PLANNING CONSULTATION RESPONSE

Application No	2026/0034
Proposal	Outline application for the erection of one dwelling with details of access and layout (other matters reserved)
Address	Land to the West of Chapel Road, Pilley, Barnsley, S75 3AR
Date of Consultation Reply	11/03/2026
Consultee	Claire Wilson, Planning Ecologist

**SITE PLAN**  
SCALE 1:100

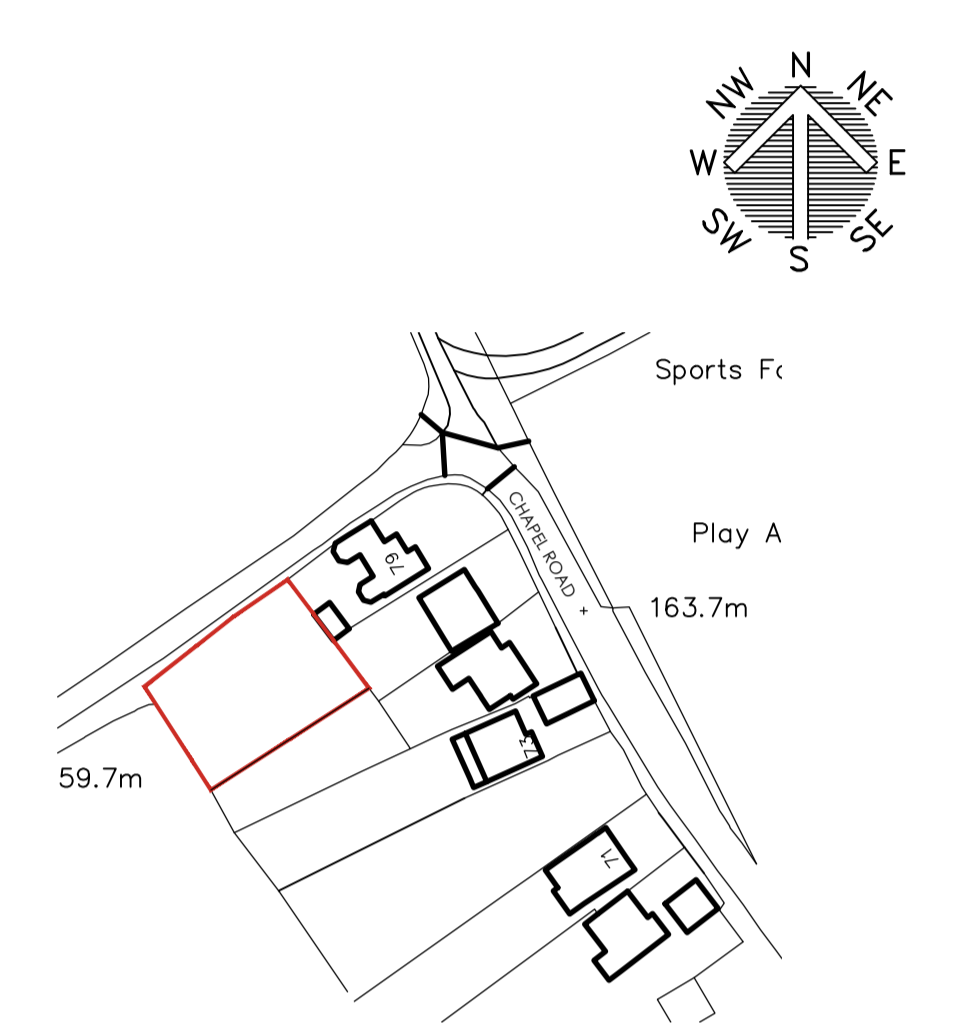
As this is an outline application, full details of the post-development habitats have not been provided. However, based on the submitted site and location plan, it appears likely that the site will be occupied entirely by a dwelling, garage and residential garden; however, the majority of trees appear to be retained on the site and location plan. Please can the applicant note that only vegetated/unvegetated garden can be included within the post-development metric for residential schemes, as no other habitat types can be legally secured within the curtilage of a residential property.
